Saffron Lodge, 46 Kingsway
Craigweil, Bognor Regis
West Sussex, PO21 4DN

Ref: **OBJECTION:** Planning Application AW/159/13 – 78 Barrack Lane - Craigweil.
Construction of a new garage within the Barrack Lane Area of Special Character.

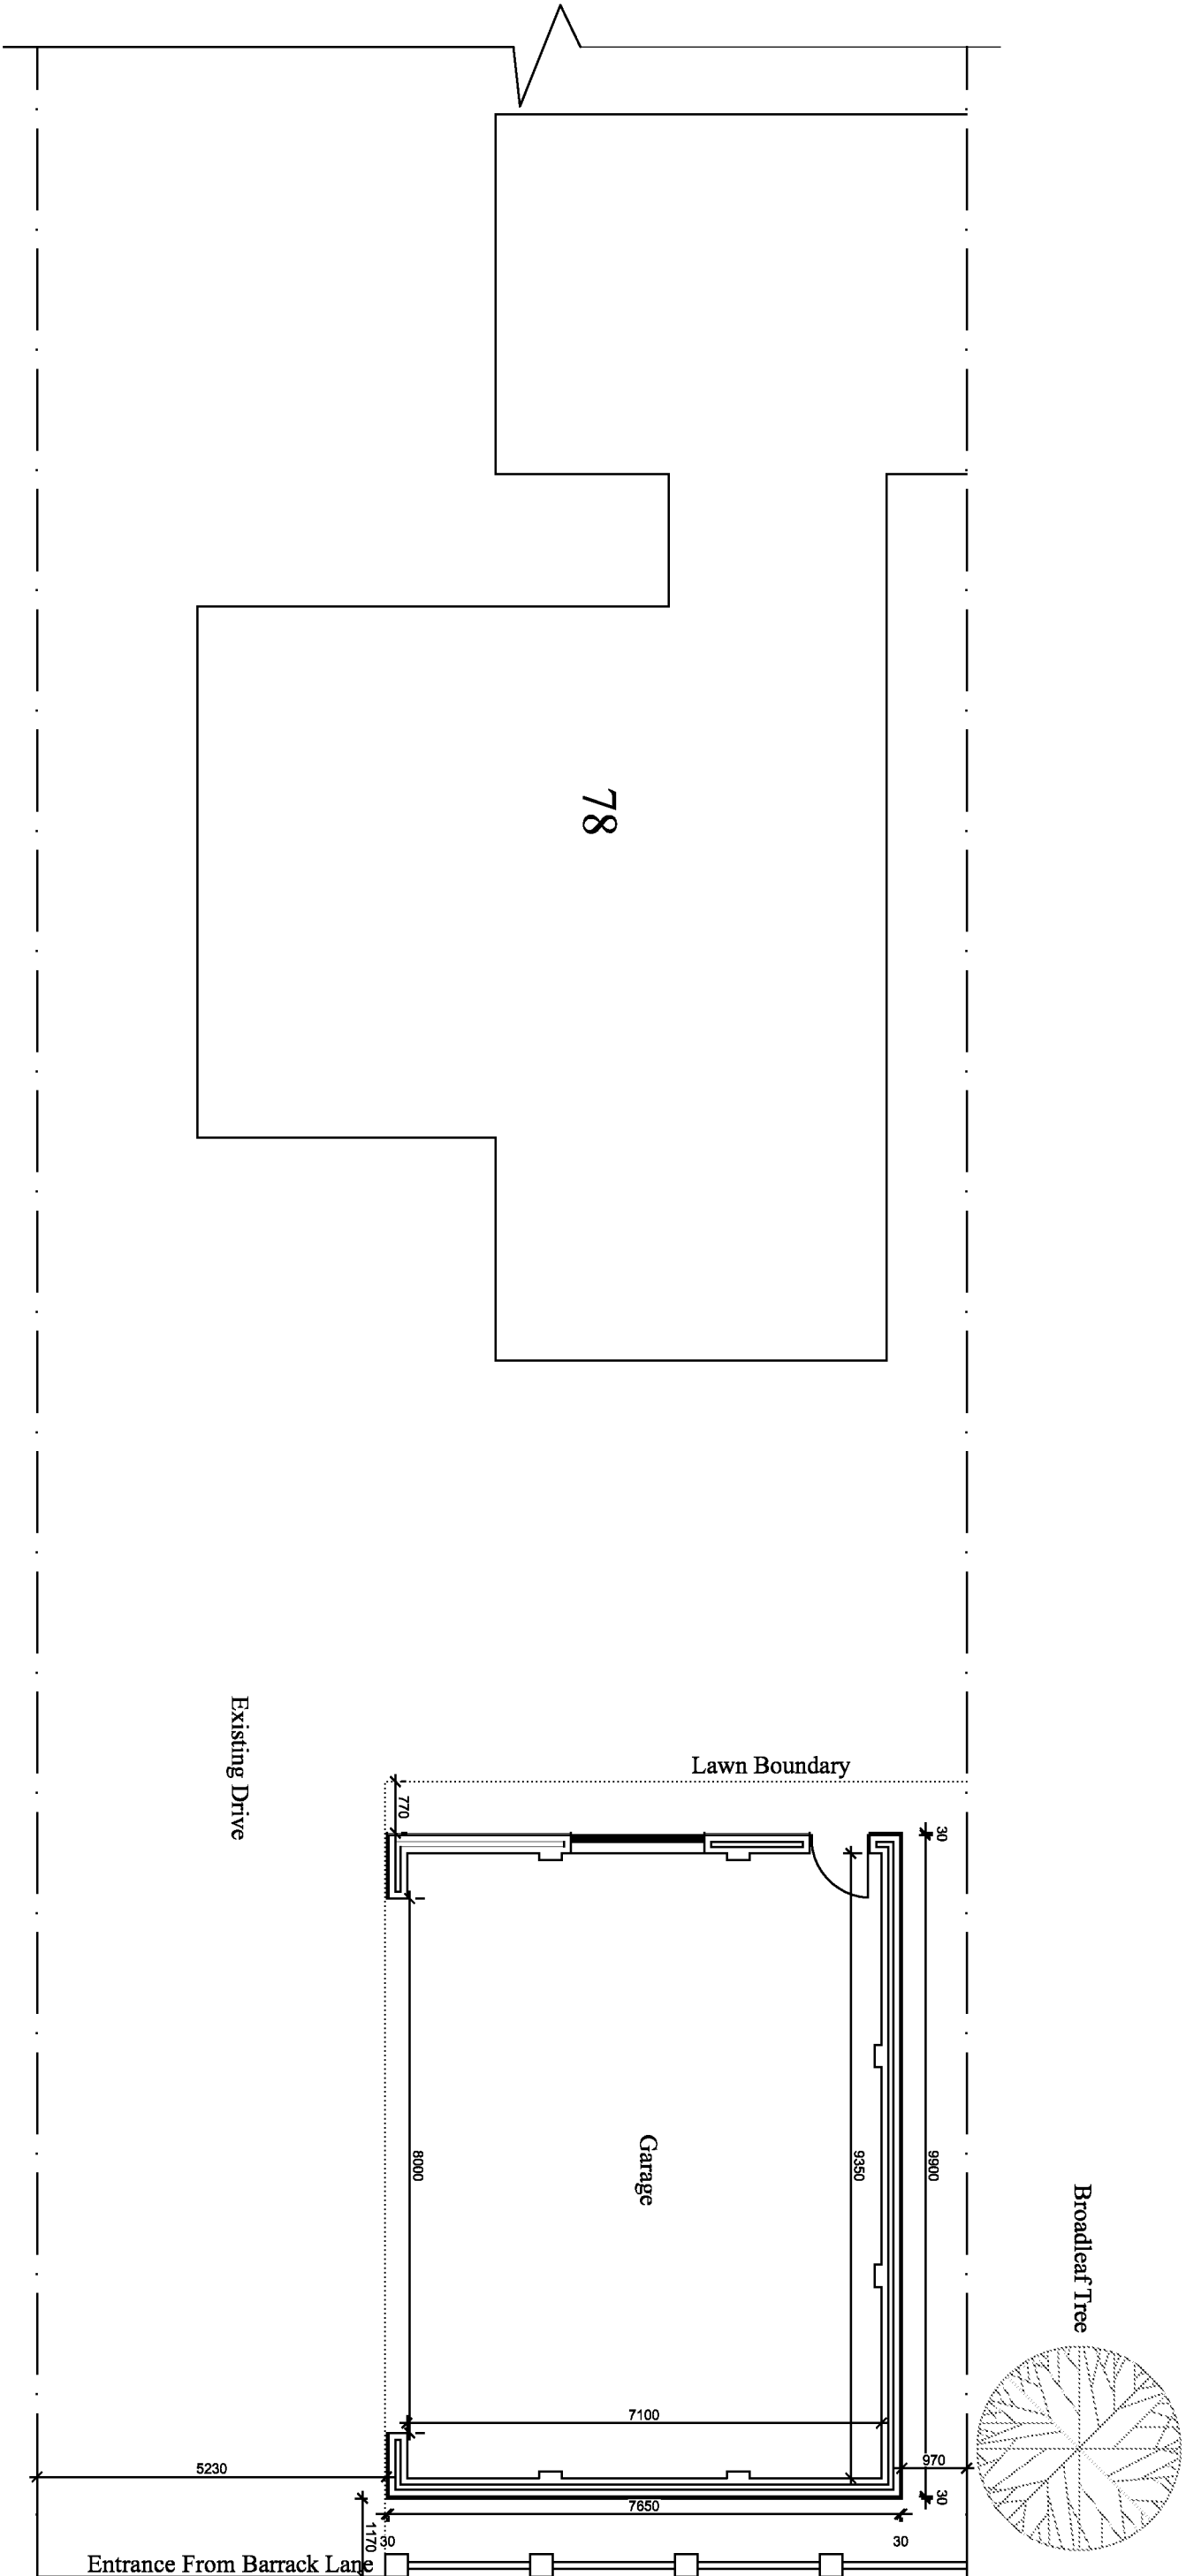
3. After studying these plans, I have to conclude that the placing of a very large garage block, sited as it is hard up against the perimeter of the Barrack lane verge/fence line and the neighbouring boundary at No. 74/76, is nothing but outrageously contradicting the policy statements for the designations listed above.

5. And again, the DLP requires plans to '**Take account of any unacceptable adverse impacts that may arise from adjoining land uses or property**'. Bringing the natural building line forward to Barrack Lane verge entirely conflicts with the immediate and distant surroundings, creating poor sightlines for the occupants and neighbours exiting onto Barrack Lane. The proposed building also impacts unacceptably upon neighbours aspects and surroundings in that part of the CHCA, creating a blockhouse into the immediate surroundings, completely out of character with the existing street scene.

8. I now turn to damage to trees in the vicinity of the Application. I see no tree survey of the site, especially in the north east area, where mature trees in the neighbouring property (74/76 Barrack Lane). The Root Protection Area (RPA) required for the trees in those/those property according to **BS5837:2012** will be entirely compromised if this garage is built in the proposed position. In my opinion, these trees should actually have a TPO placed upon them and **I ask that that be arranged ASAP.**

Proposed Front Elevation - Street View

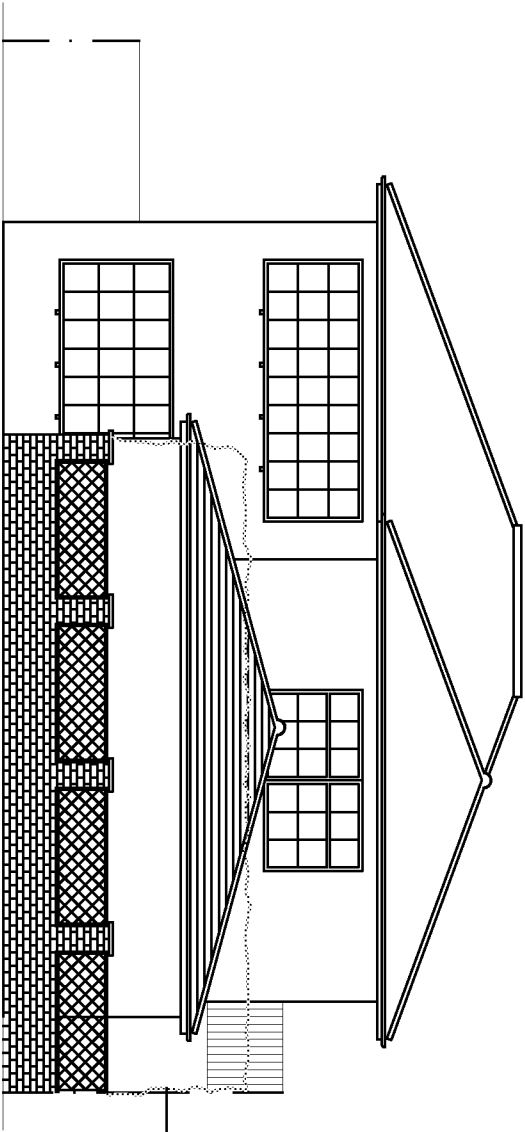
4. Quoting from Policy GEN 7 of the DLP '**New development must make a positive contribution to the quality of the environment**'. This Application makes no such contribution, its bulk and size and placement show it to be intrusive, overbearing and an ugly addition to the surroundings.

6. The DLP then says plans must '**Retain significant open areas which in their own right, make a material contribution to the local environment**'. Placement of the blockhouse garage will destroy the open nature and appearance of the surrounding properties of Barrack Lane and have a very negative 'contribution' to the street scene/environment.
